# CITY OF ALBUQUERQUE

June 2, 2021

**Re: Stripes On Lomas  
6121 Lomas NE  
Traffic Circulation Layout  
Architect's Stamp NONE PROVIDE (J18-D021A)**

SHEET
TCL2

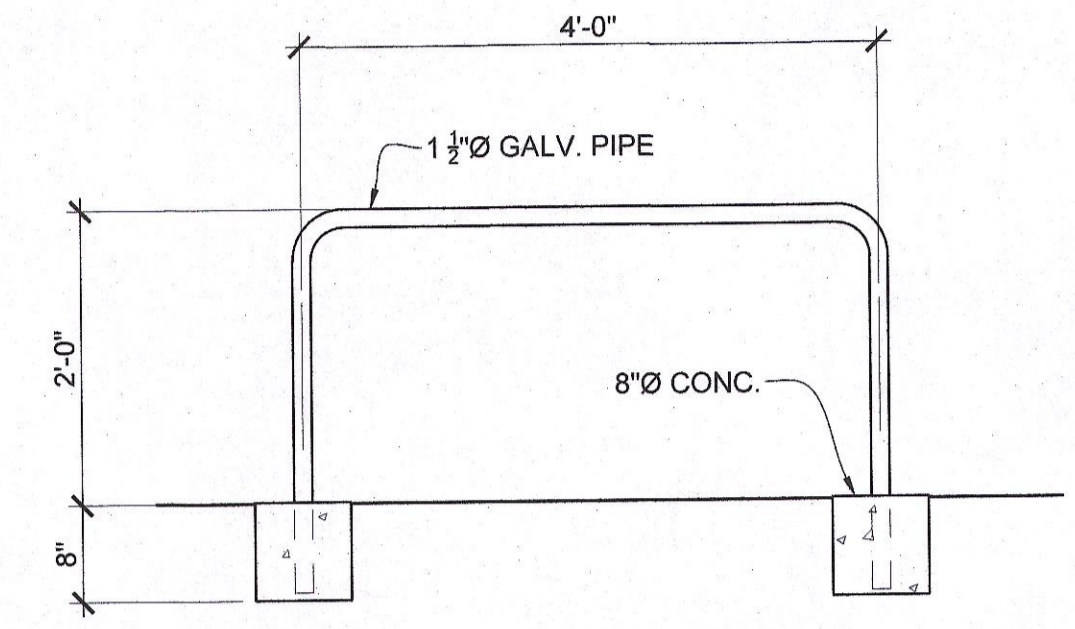
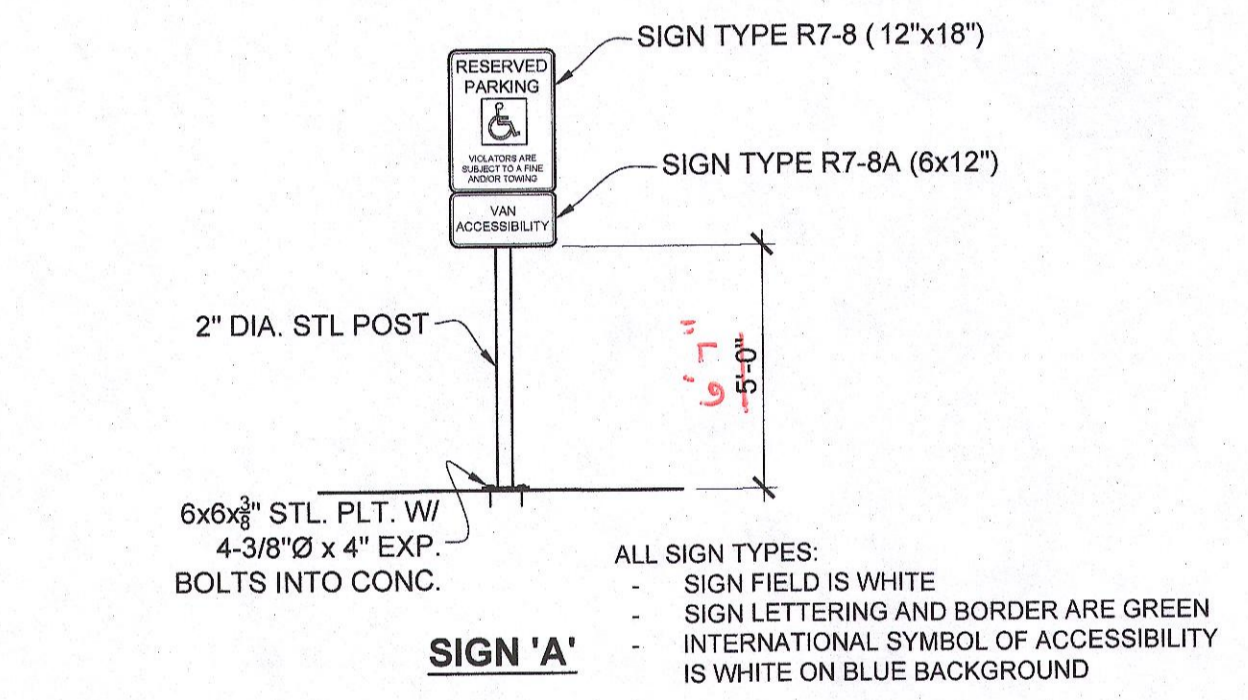
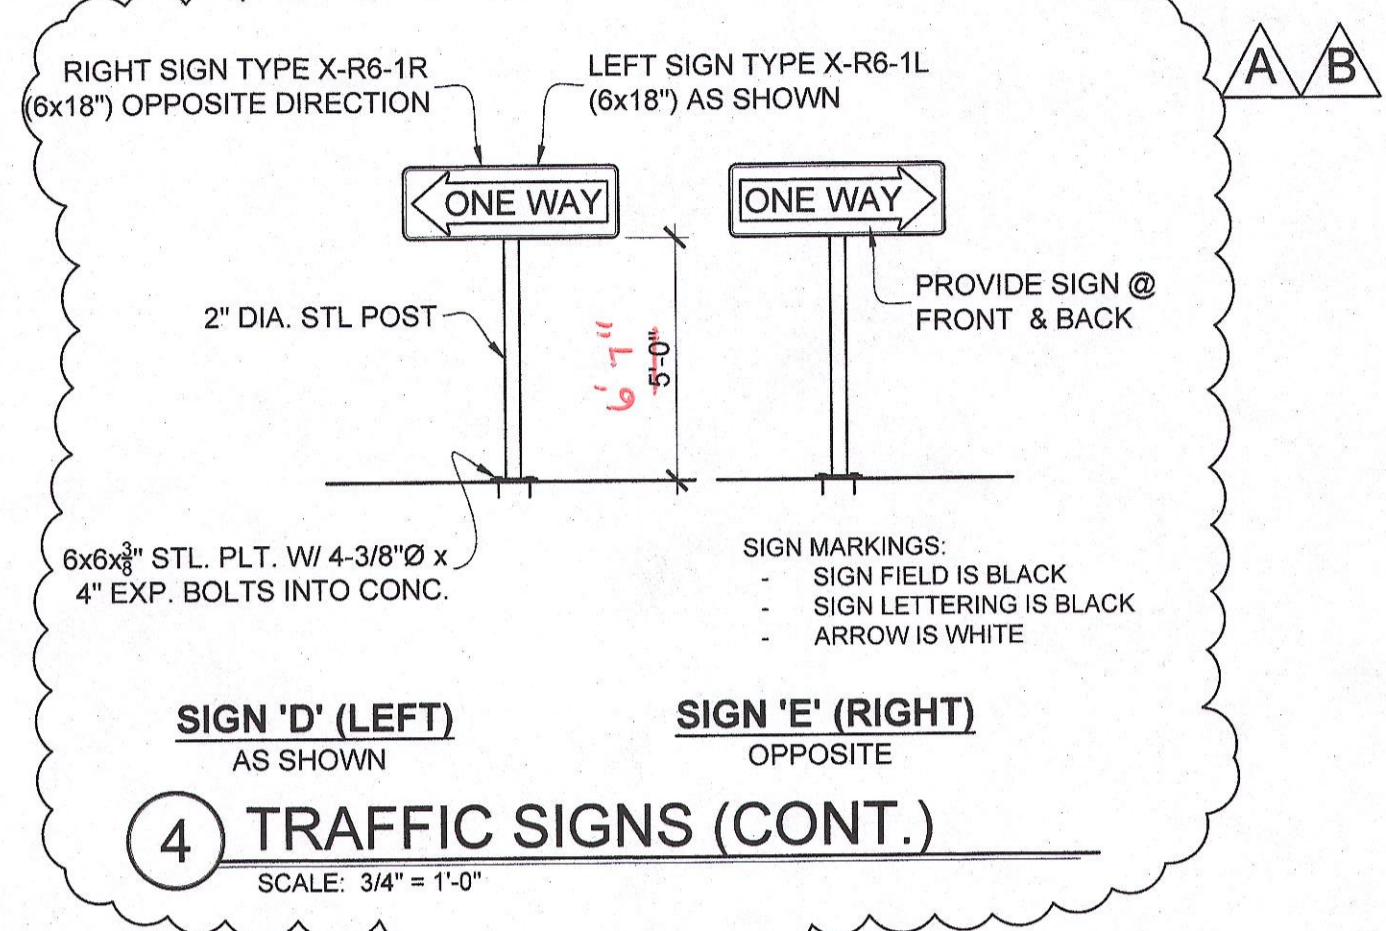
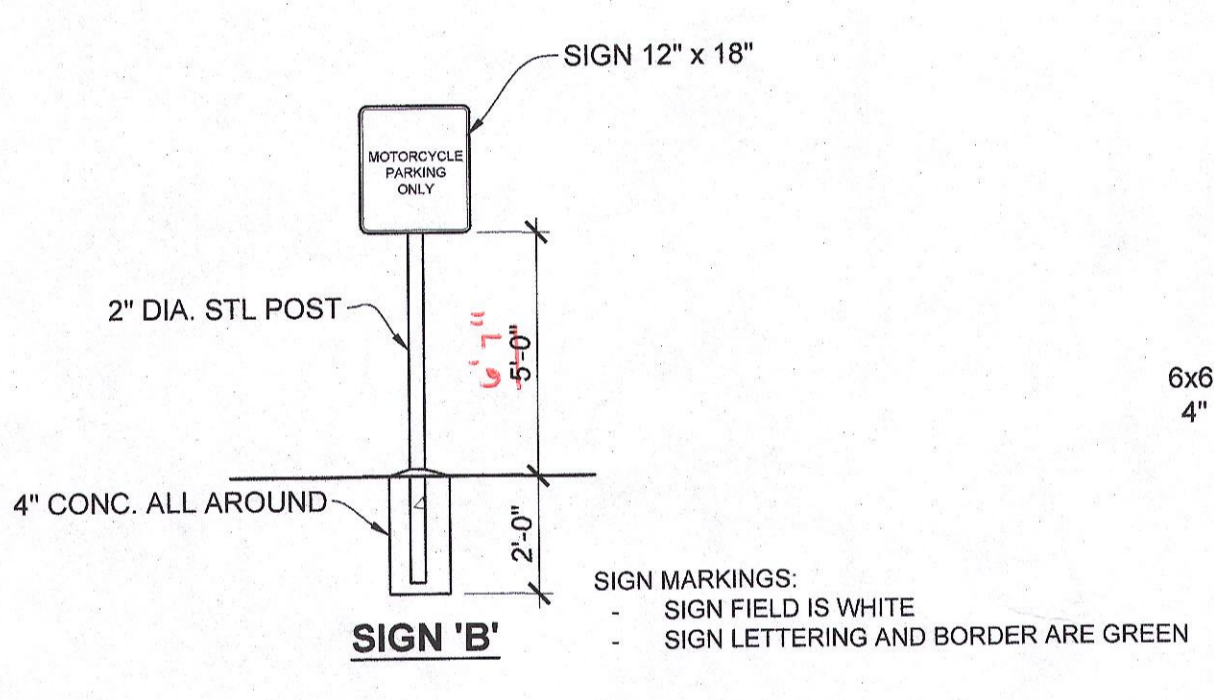
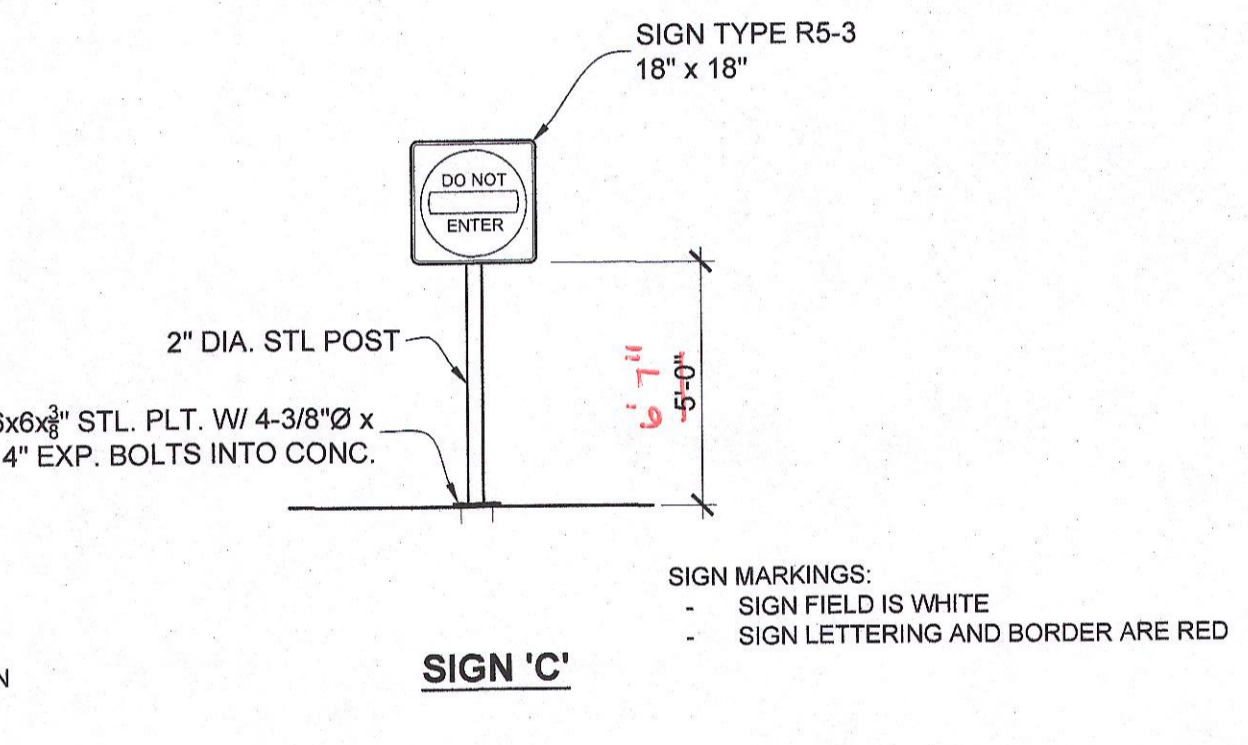
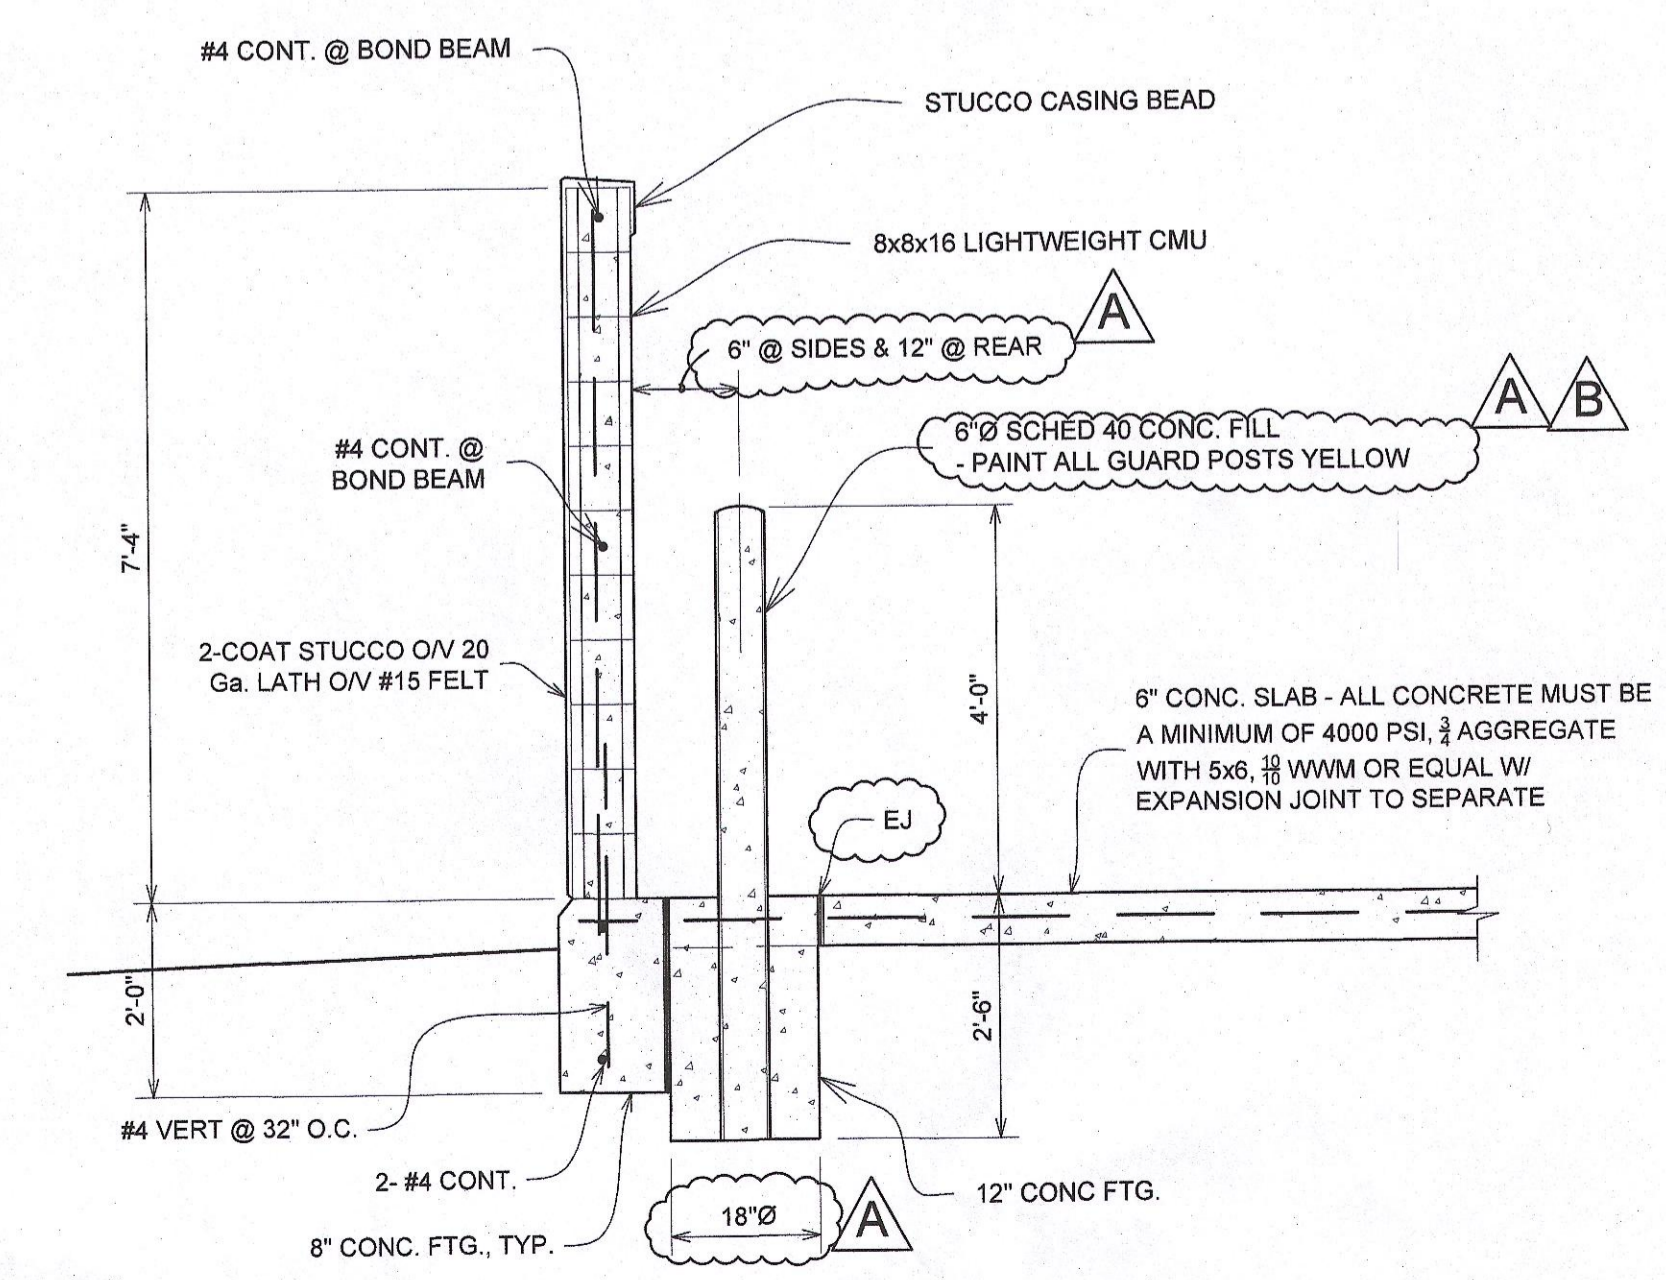
25. All one-way drives shall have "One Way" and "Do Not Enter" signage and pavement markings. **Please show detail and location of posted signs and striping. Provide details of the pavement markings and sign face (All will need to be provided, especially for the one-way orientation).**
